Application by NNB Generation Company (SZC) Limited for an Order Granting Development Consent for The Sizewell C Project

The Examining Authority's third written questions and requests for information (ExQ3)

Issued on 09 September 2021

B SECTION
SCALE 1:100

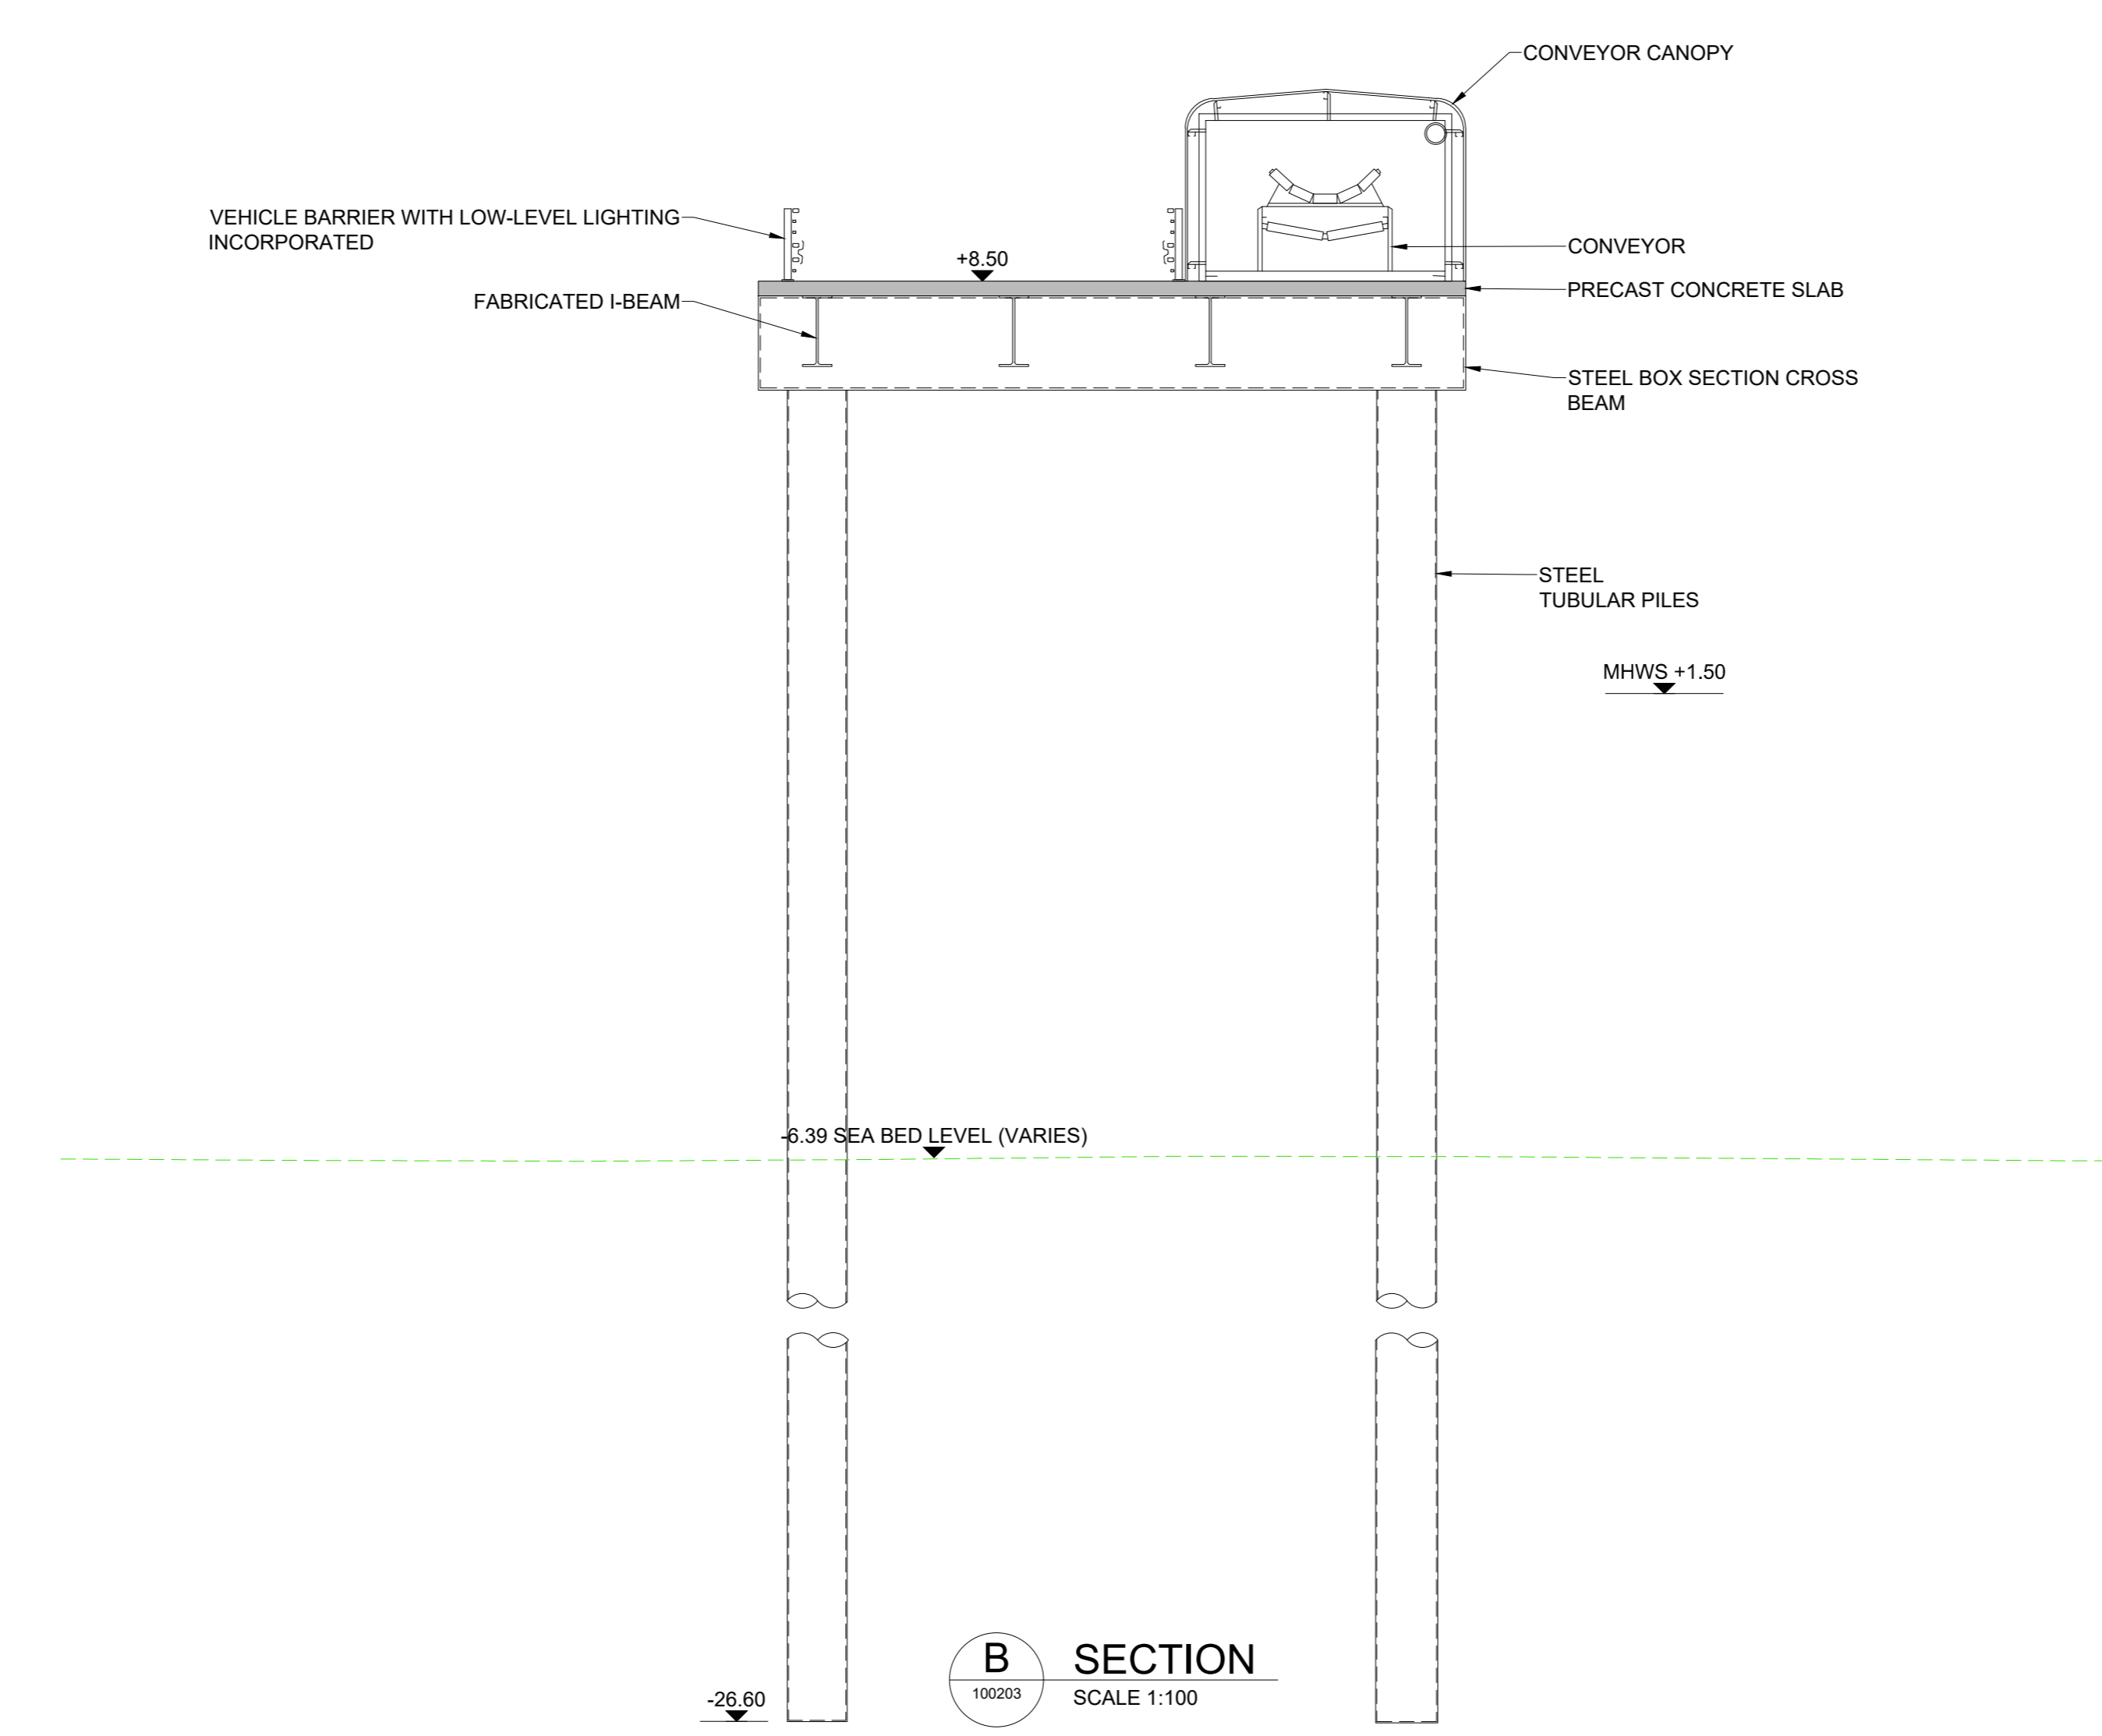
CG.3.10	The Applicant	<p>Impacts on coastal processes:</p> <p>The Deadline 5 submission of Bill Parker [REP5-191], states that the Applicant has yet to define its methodology for 'ground improvement' that will be a critical element in determining the resilience of the development in the long-term. Please indicate whether this methodology and details of ground improvement works been determined. If so, when will this information be submitted to the Examination? If not, how can a determination of future resilience be made in the absence of that information?</p>
CG.3.11	The Applicant	<p>Impacts on coastal processes:</p> <p>The Deadline 5 submission of Bill Parker [REP5-191], seeks details as to how the HCDF would be integrated with the SSSI crossing, the BLF and jetty. The Applicant has</p>

ExQ3	Question to:	Question:
		submitted drawings at Deadline 7 relating to the permanent and temporary BLFs and SSSI crossing. Please explain in detail including by reference to any submitted plans how that would be achieved?
CG.3.12	The Applicant	Impacts on coastal processes: The Deadline 5 submission of Bill Parker [REP5-191], states that there needs to be a recognition that Sizewell Bay is a complex and dynamic environment. (i) Please explain how the assessment of long-term impacts have taken account of integrated system elements of the design and the potential for "emergent behaviour" from the natural environment? (ii) Should an independent expert assessment of the system elements operating in combination be carried out? (iii) If not, why is this not considered to be necessary?
CG.3.13	The Applicant	Impacts on coastal processes: The Deadline 7 submission of Nick Scarr highlights the fact that the adjoining Sizewell B has a 10m AOD sea defence crest height and the new proposed sea defence for Sizewell C (14.6-16.4m AOD) does not appear to cover the frontage of Sizewell B. Whilst paragraph 3.2.21 in the Applicant's 'Sustainability Statement [APP-617] is noted, please explain the apparent discrepancy and how any potential risk posed by the Sizewell B defences to either site in the long-term would be overcome and secured by the draft DCO?
